**Consultation Response from Mike Hibbert,
KC Waste Strategy(Refuse & Recycling)**

2023/90772 Land at, Penistone Road, Fenay Bridge, Huddersfield, HD8 0AW

Discharge conditions 3 (CEMP), 7 (waste collection), 14 (soft landscape), 17 (boundary treatment), 25 (tree/shrub planting) on previous permission 2020/90725 for erection of 68 dwellings with associated access, parking and open space (revised plans)

Responding Ref: WPS 23-15

Drawing Title	
Construction Management Plan	
Site	
Penistone Road, Fenay Bridge	
Scale @ A1	Date
1:500	06.03.23
Drawn	Checked
BH	.
Drawing No.	Rev.
FB-006	B

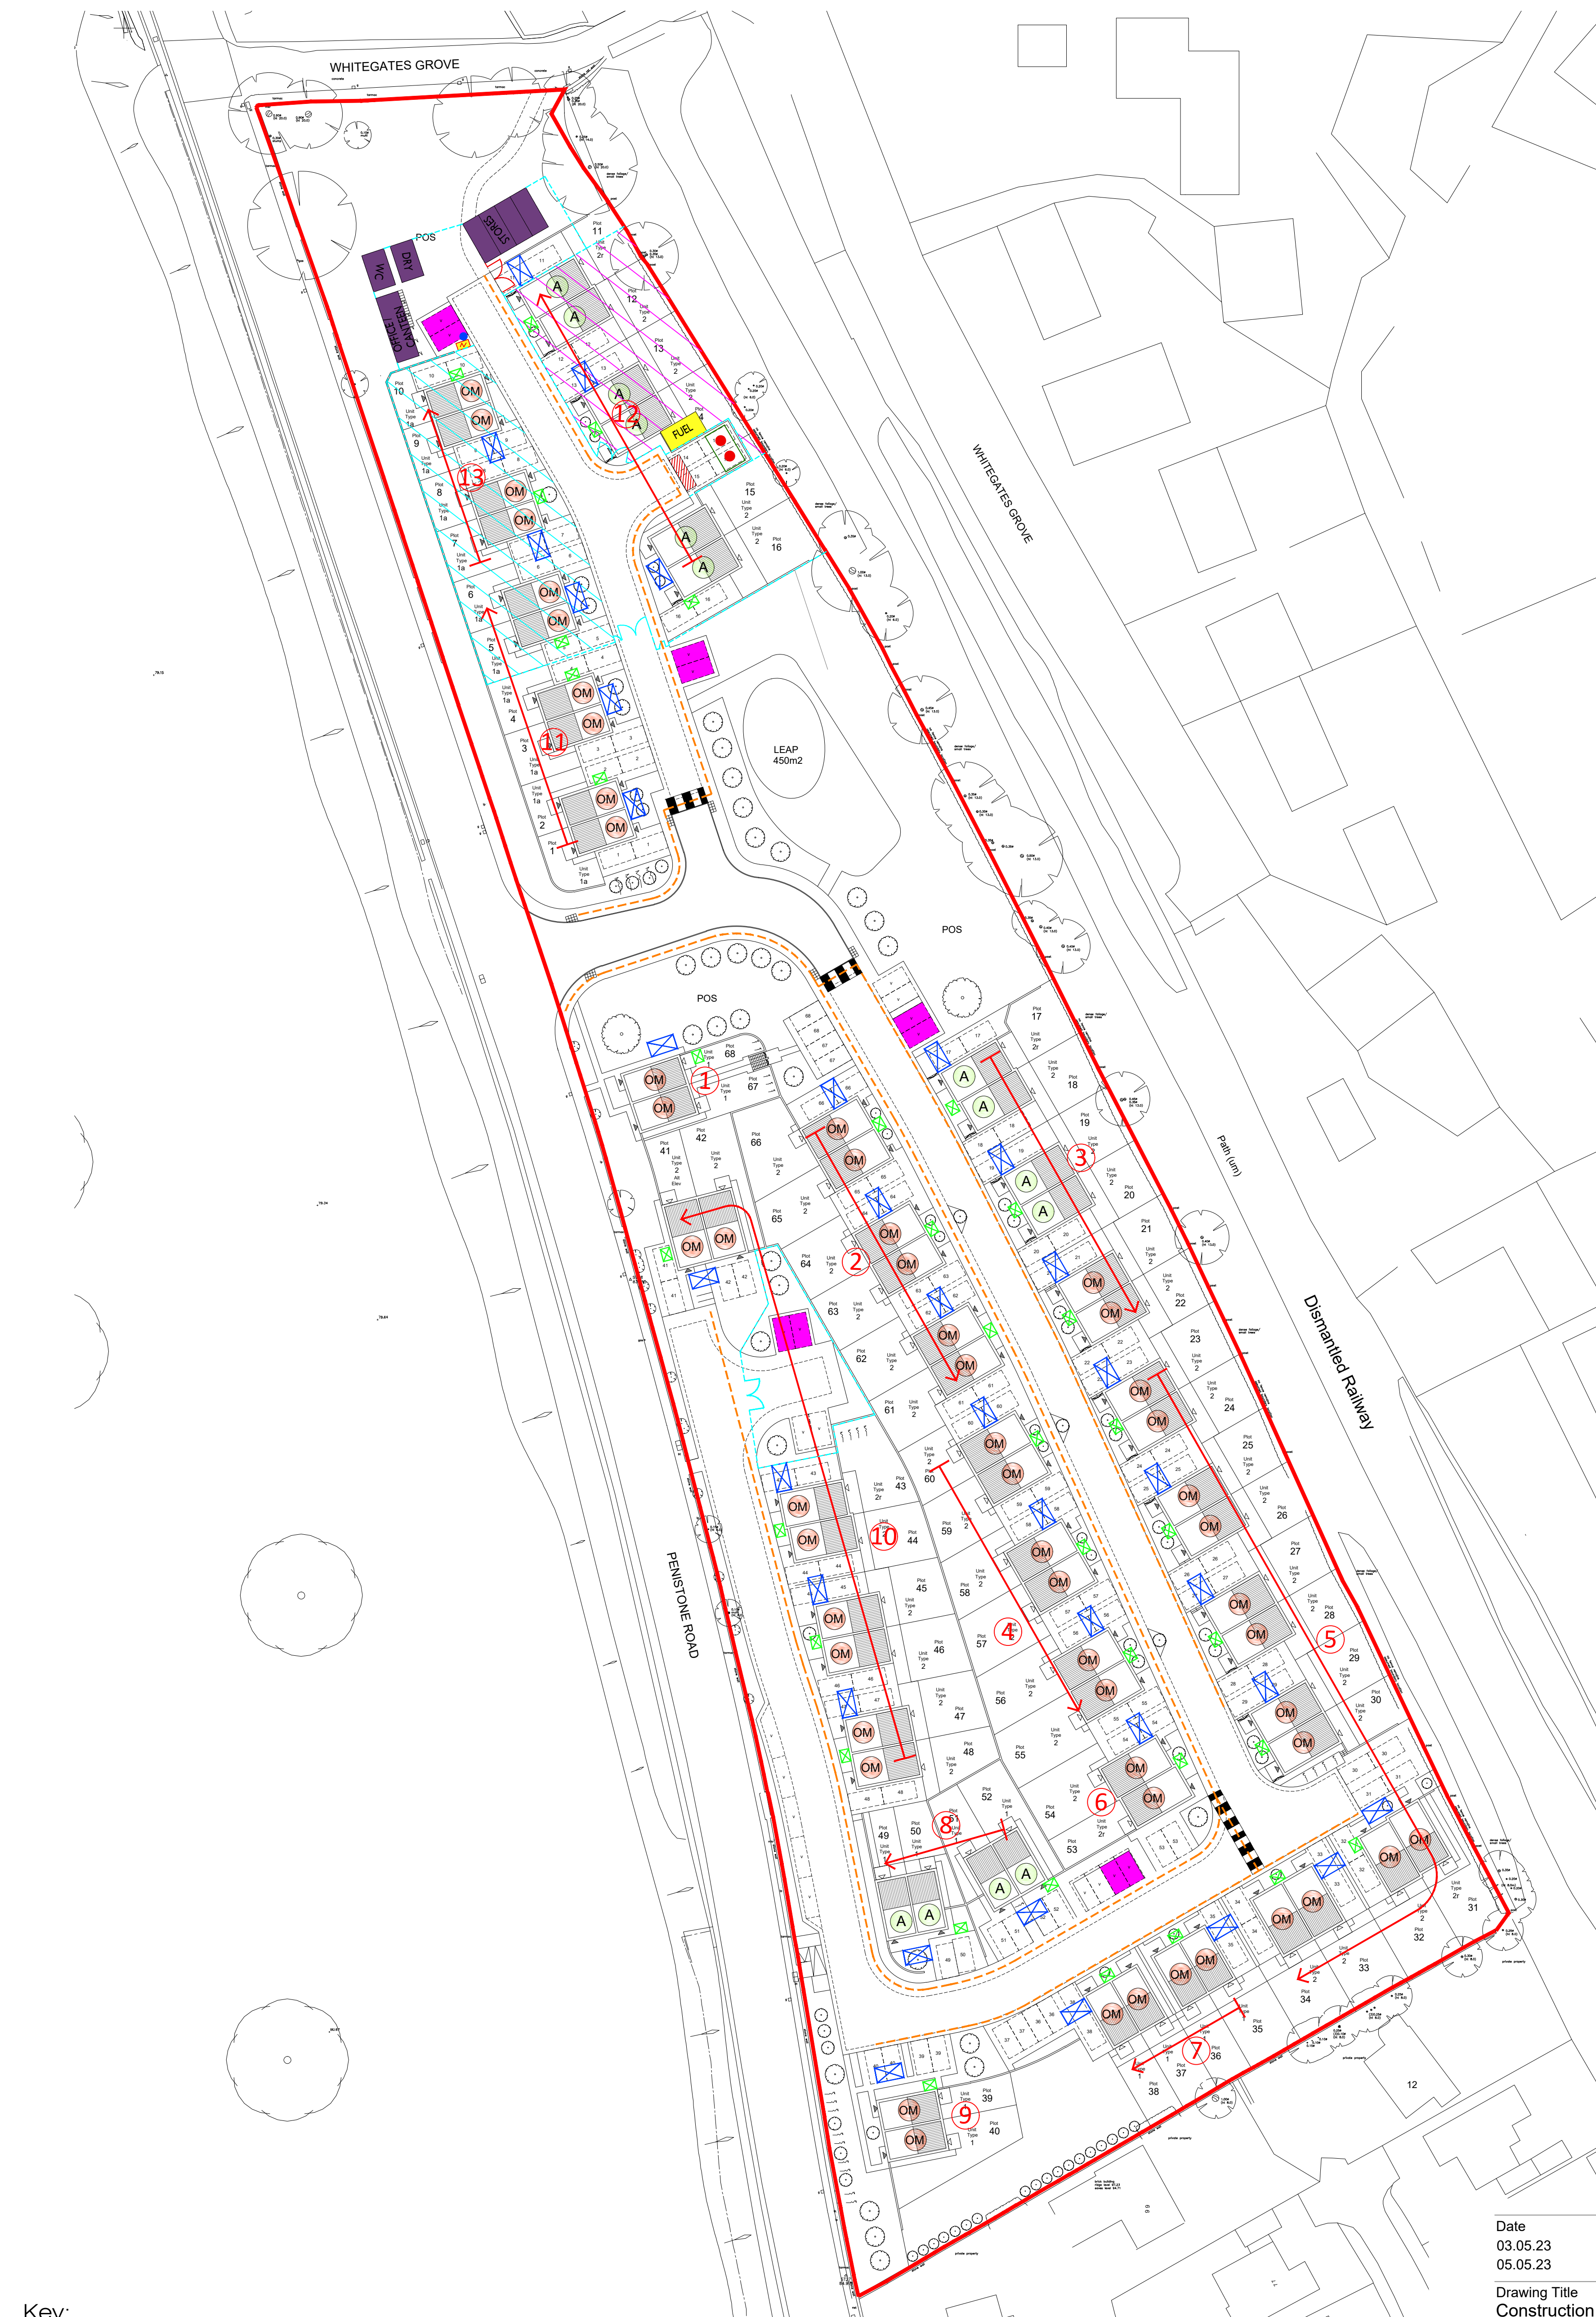
The applicant has submitted a covering letter dated 3rd March 2023 that for Condition 7 (Temporary Waste Collection) refers to Temporary waste Collection details but provides no additional information. The application also includes plan ref: Dwg FB-006 dated 06.03.23 that is annotated with the phasing for the site but has no indication of proposed location of temporary bin store locations for use during staged occupation by new residents.

- The Waste Collection Authority will not enter active construction sites with a Refuse Collection Vehicle (RCV). The rationale is to avoid damage to RCV's due to inadequate roadways, potential impact between RCV's or collection crew with contractors' plant/ delivery vehicles and remove the necessity for collection staff to undertake mandatory health and safety induction by the site manager.

- The WCA will require the identification of a location close to the entrance of each phase, accessible from an adopted highway or other accessible road within the development, where temporary waste collection or bin collection points can be established.

- The WCA requires a meeting on site with the applicant, developer or site manager to discuss/ identify locations and confirm requirements in relation to access, surfacing and security for the temporary bin or waste collection points.

- Residents should not normally have to present their 240ltr wheeliebins at temporary Bin Collection Points if the drag distance is more than 25m.
- Temporary waste collection points shall consist either of a compound where containers will consist of either 1100ltrs Wheeliebins or in specific cases a closed skip. The

- When residents move into properties the WCA expectation is that residents either have a short drag out of their wheeliebin to a BCP, drop off bags of their waste at the communal collection point/ temporary bin store near the site entrance or the developer can arrange collection from households and deposit waste at the temporary store until such time as the construction phase is released and routine kerbside bin collections from individual dwelling commences.
- If an RCV or skip wagon is entering a site to service a temporary waste store, then there must be demarcation such that a turning head is fenced off from the active construction site. Long reversing manoeuvres by RCV's is a recognised safety risk for both collection staff and members of the public and must be avoided.

The WCA will not agree to discharge of this condition until the above requirements are met.
